The Barn Hotel, West End Road, Ruislip

LPA REFERENCE 7969/APP/2023/1473

RESPONSE TO LB HILLINGDON FEEDBACK

'URBAN DESIGN AND CONSERVATION' COMMENTS

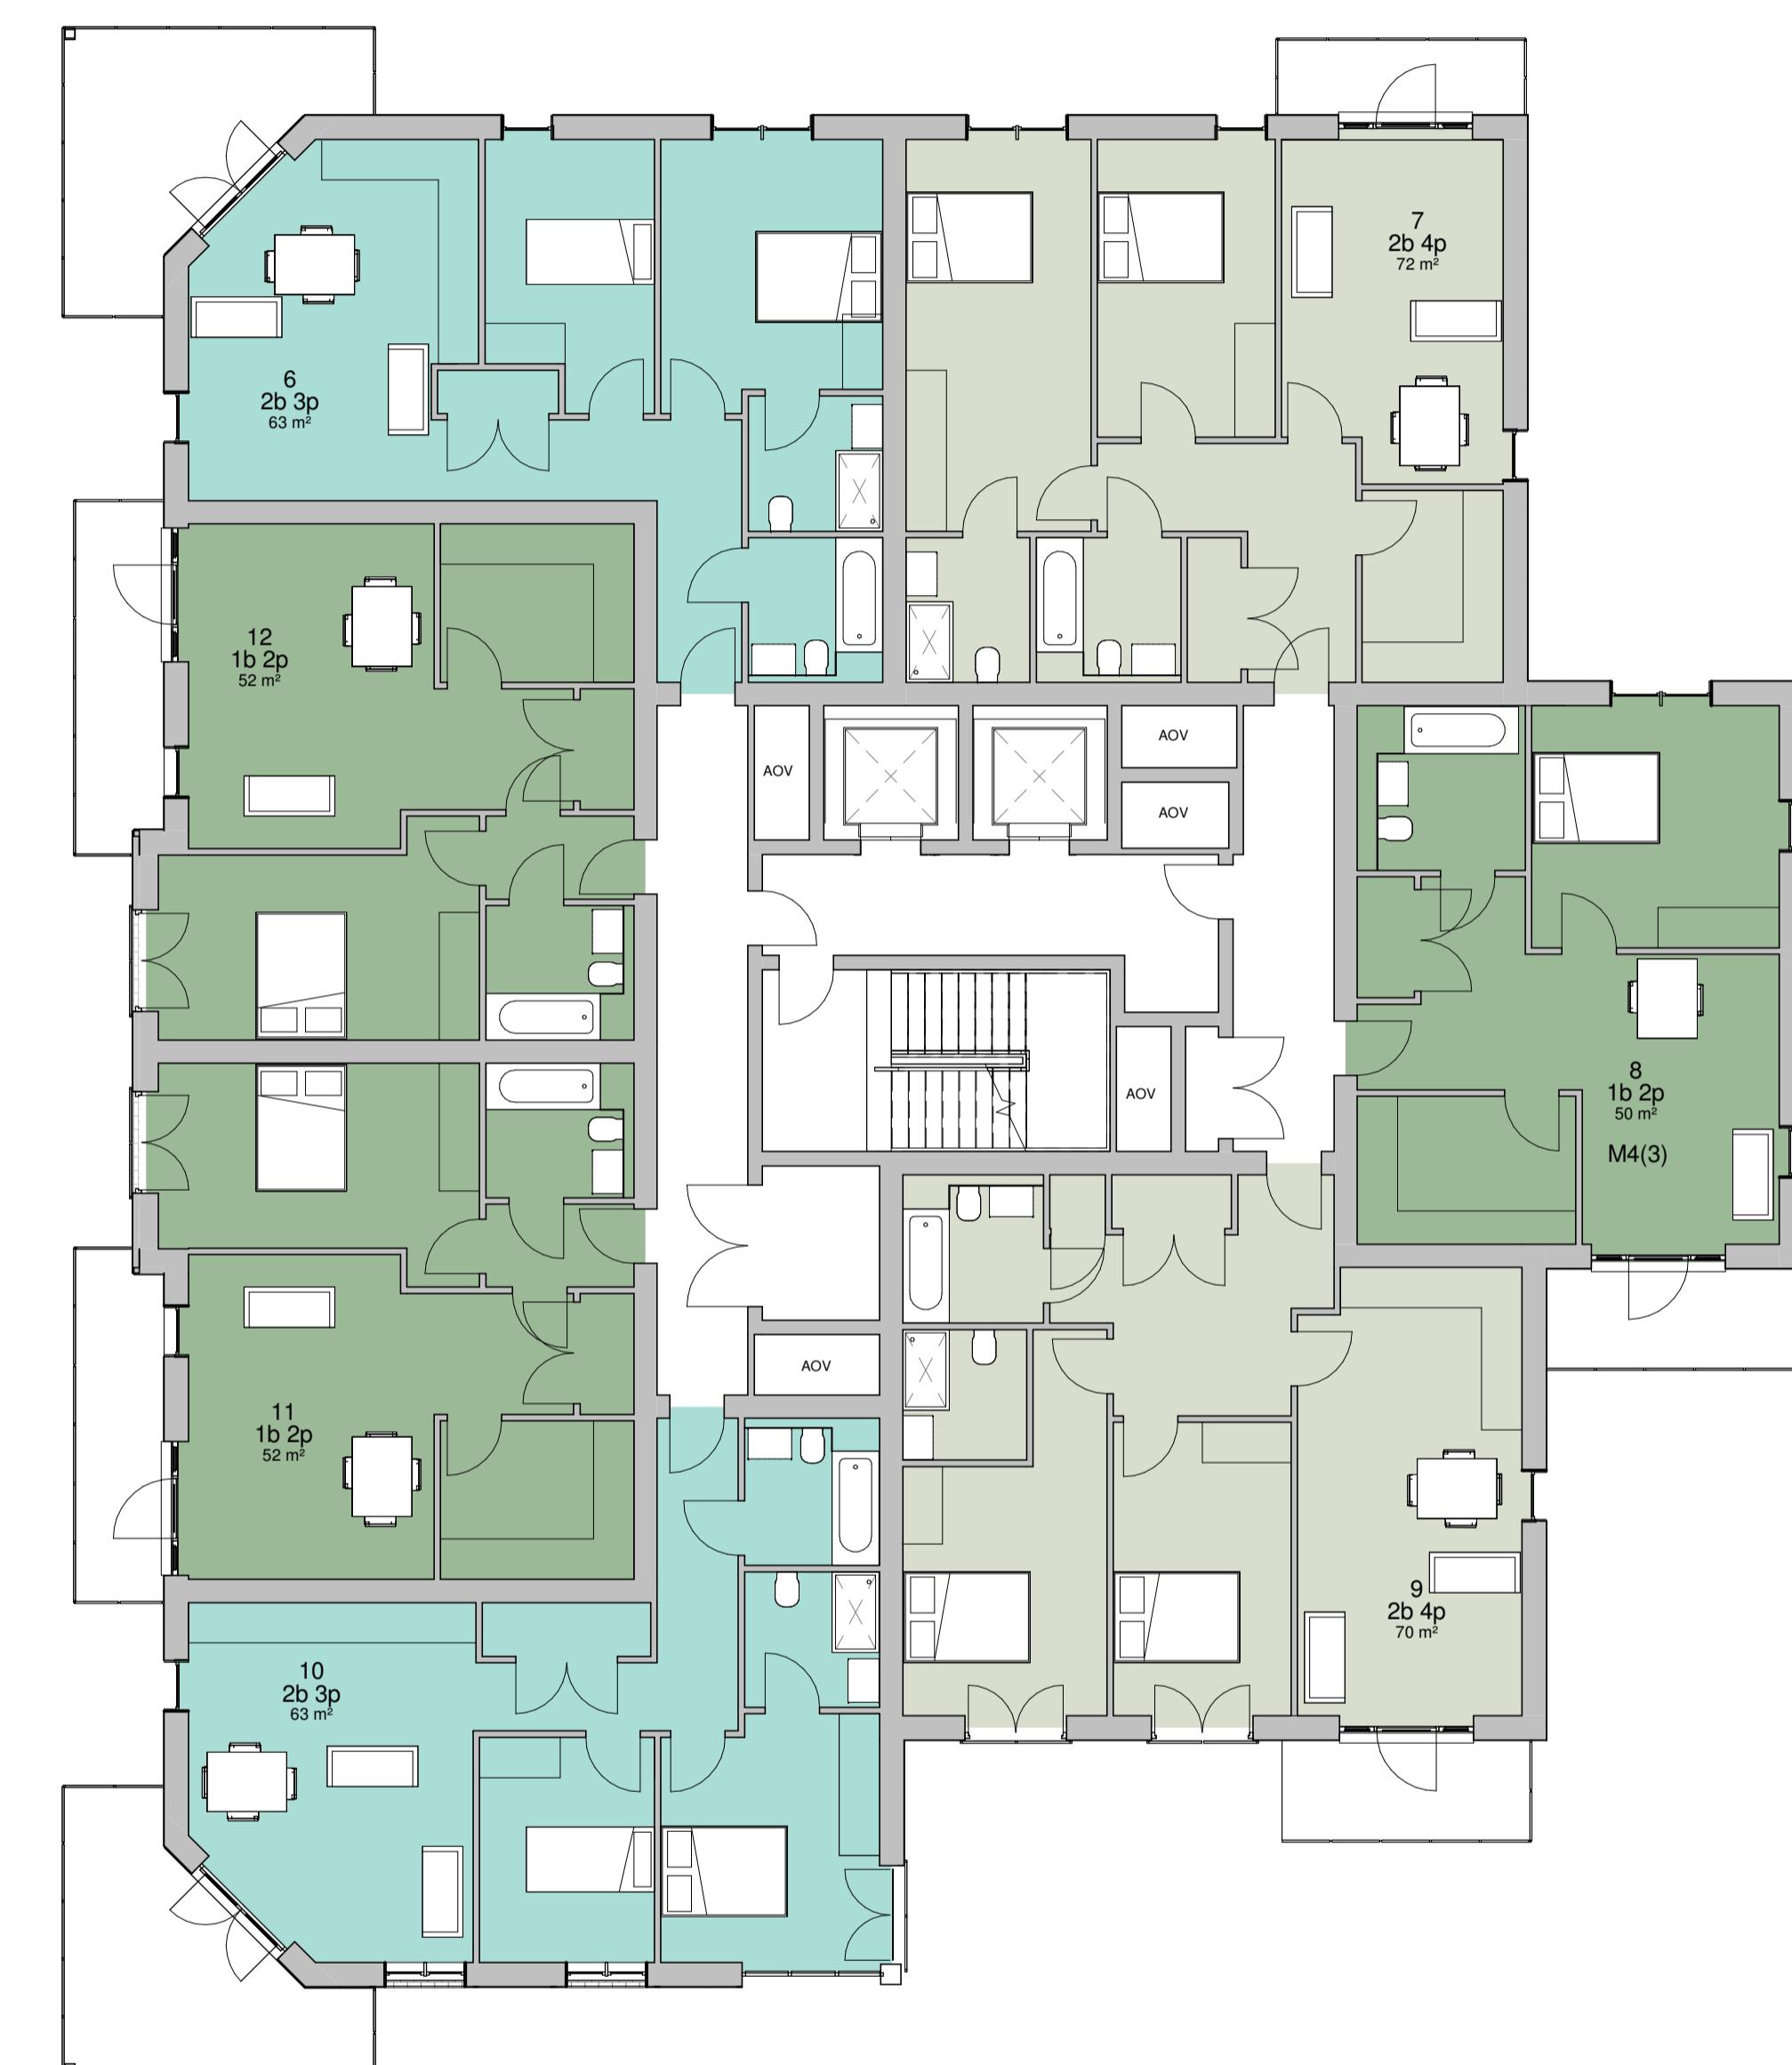
'the separation distance between the windowed elevation of Building 2 to the proposed unit 89 of approximately 16m.'

The windows on the Building 2 rear (east) elevation are ancillary slot windows and they will be obscure-glazed with limited opening. This can be controlled by condition.

The windows on the side (north-eastern) are clearly highly oblique and do not offer direct overlooking with the houses. If the perceived issue relates to the balcony, an obscure screen fixed to the eastern side of the balconies on the northern elevation can reasonably be secured by condition.
